Hampshire Water Transfer and Water Recycling Project

Plans of statutory and non-statutory sites or features

APPLICATION DOCUMENT REFERENCE: 2.7

Document Control		
Title	2.7 Plans of statutory and non-statutory sites or features	
Version History		
Version	Date	Status/Reason for Issue
Version 0	21 May 2026	DCO Submission
Version 1	17 July 2026	S51 Advice

Figure 8.3
Non-statutory designated sites within the desk study area
Sheet 4 of 16

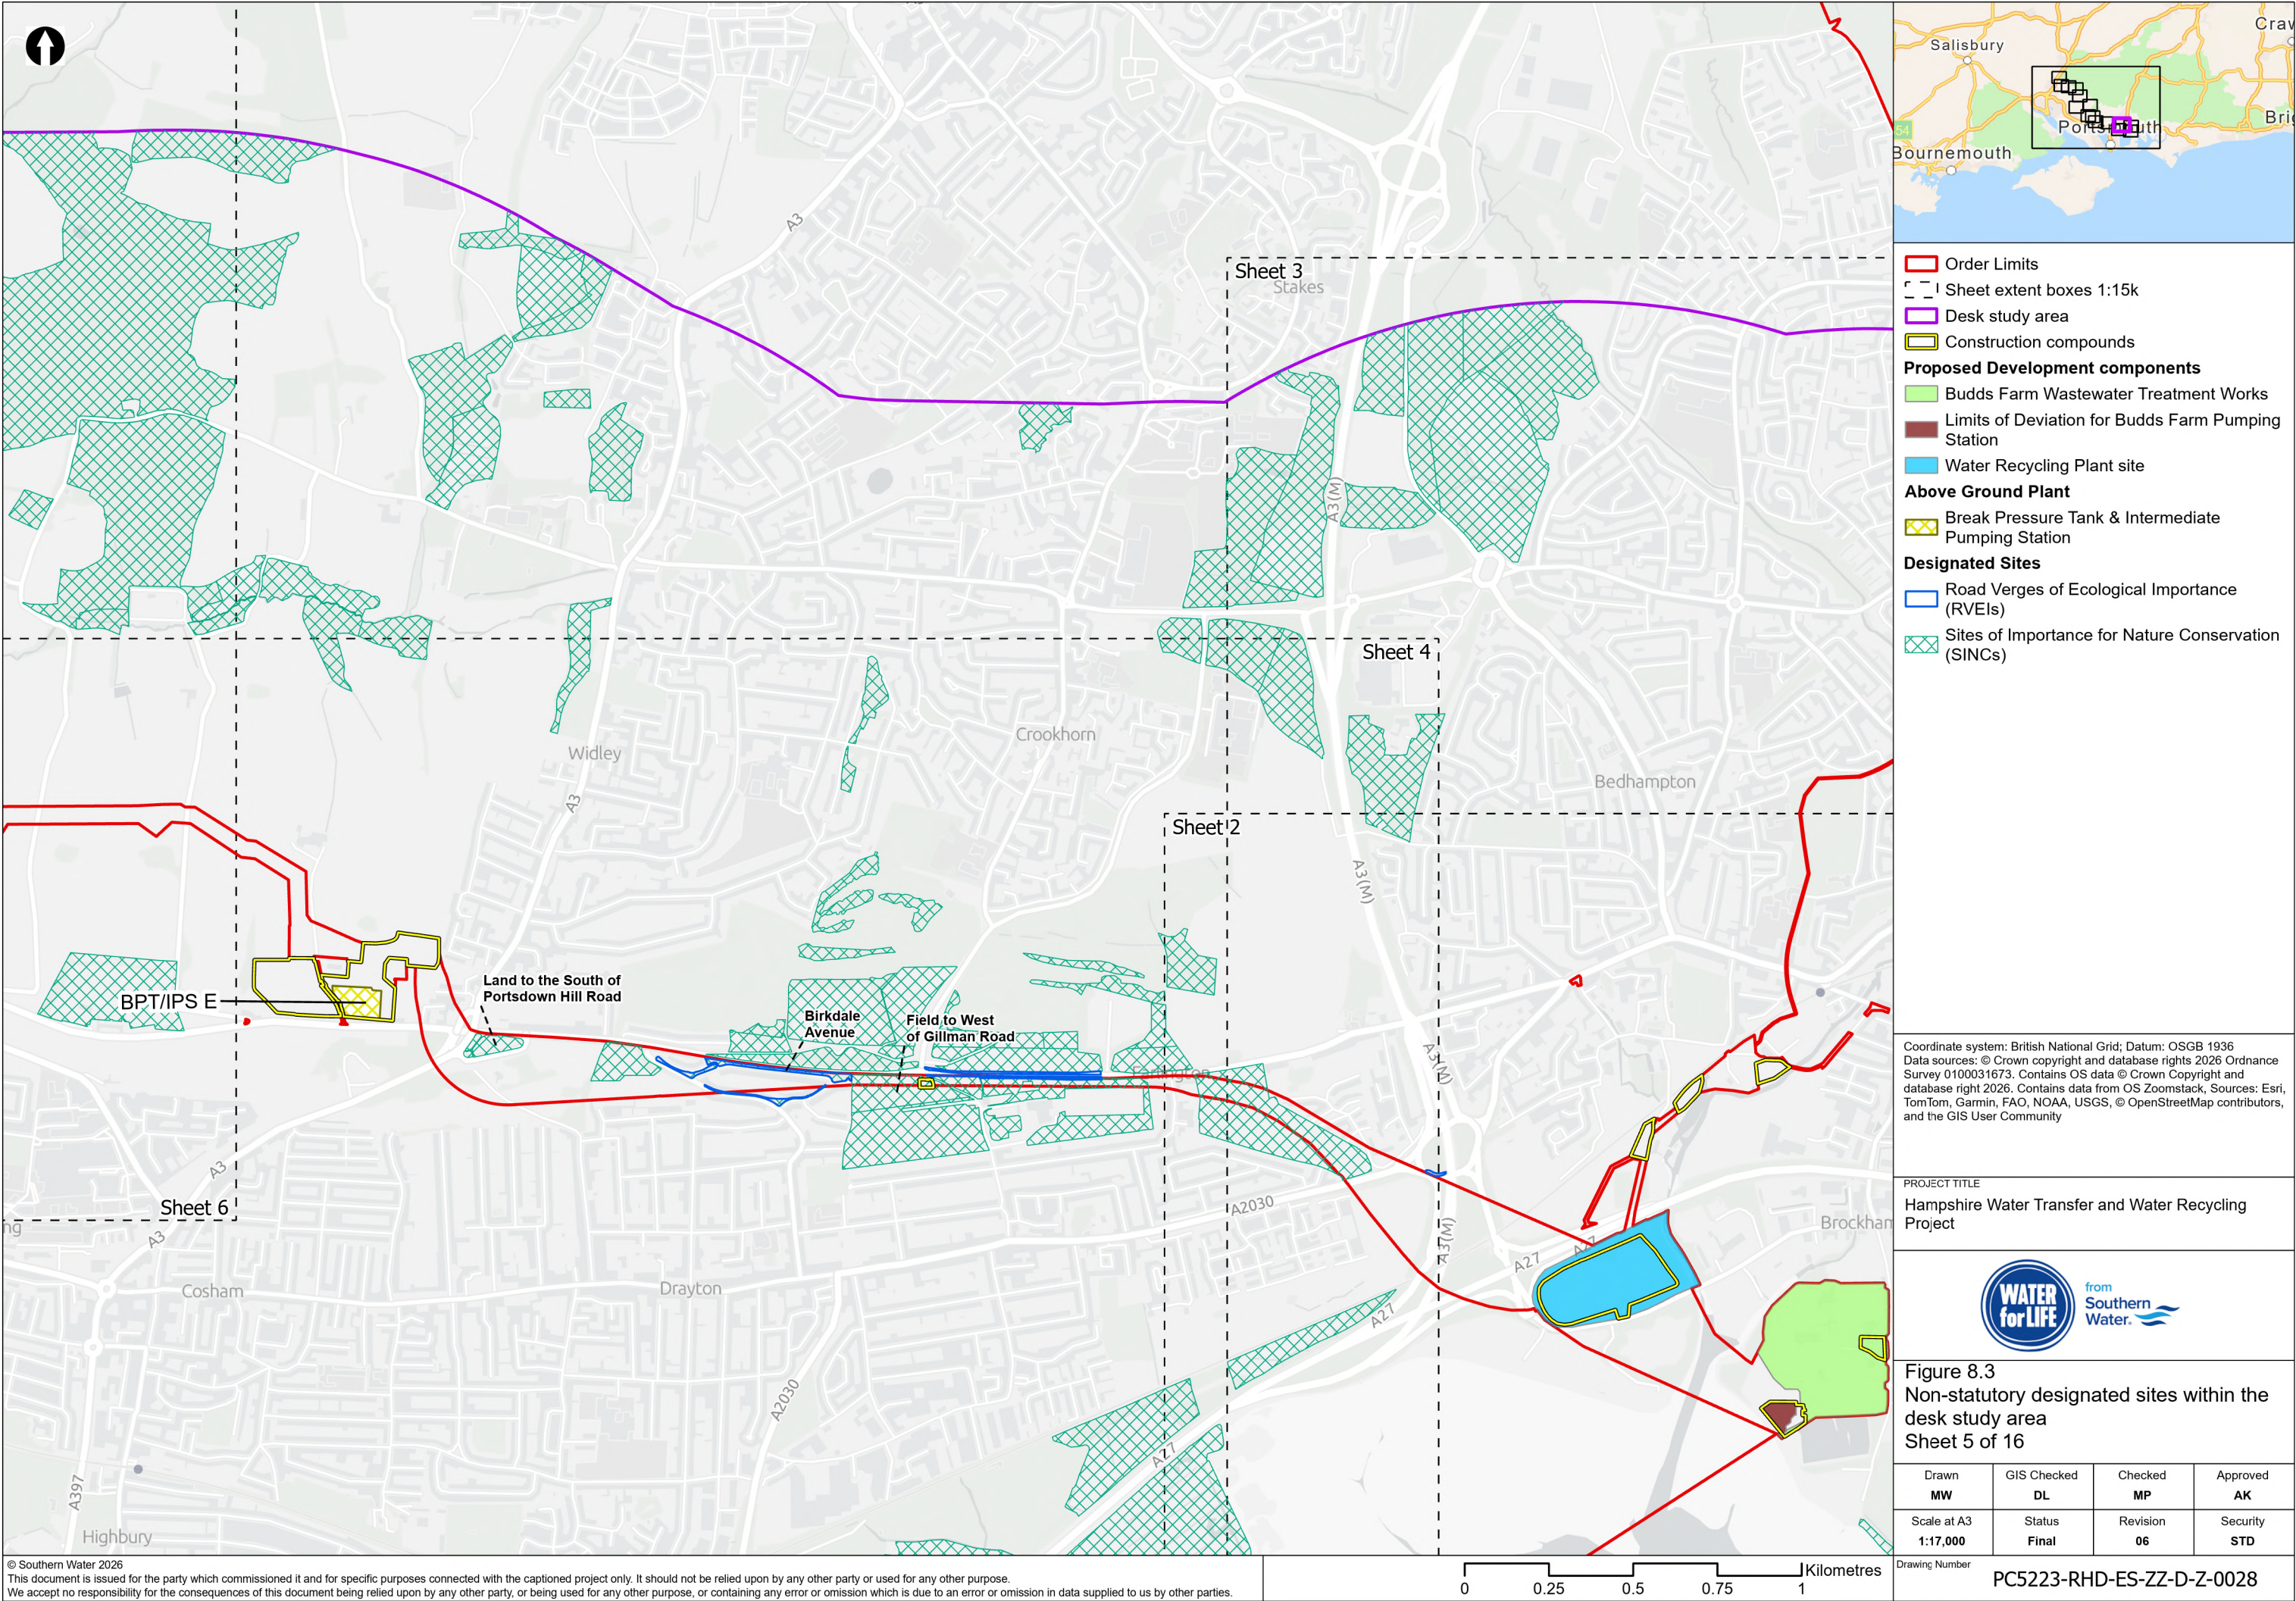
ES Vol III – ES Figure 8.3 Non-statutory designated sites within the desk study area			
PC5223-RHD-ES-ZZ-D-Z-0028	Figure 8.3 Non-statutory designated sites within the desk study area SHEET 4 OF 16	06	All Sites of Interest for Nature Conservation (SINC) and Road Verges of Ecological Interest (RVEI) included in the ecology assessment (ES Chapter 8) added to figure: - Field West of Gillman Road SINC - Birkdale Avenue RVEI - Land to the South of Portsdown Hill Road SINC
PC5223-RHD-ES-ZZ-D-Z-0028	Figure 8.3 Non-statutory designated sites within the desk study area SHEET 5 OF 16	06	All SINC and RVEIs included in the ecology assessment (ES Chapter 8) added to figure: - Field West of Gillman Road SINC - Birkdale Avenue RVEI - Land to the South of Portsdown Hill Road SINC
PC5223-RHD-ES-ZZ-D-Z-0028	Figure 8.3 Non-statutory designated sites within the desk study area SHEET 6 OF 16	06	All SINC and RVEIs included in the ecology assessment (ES Chapter 8) added to figure: Motte & Bailey & Chalk Pit SINC
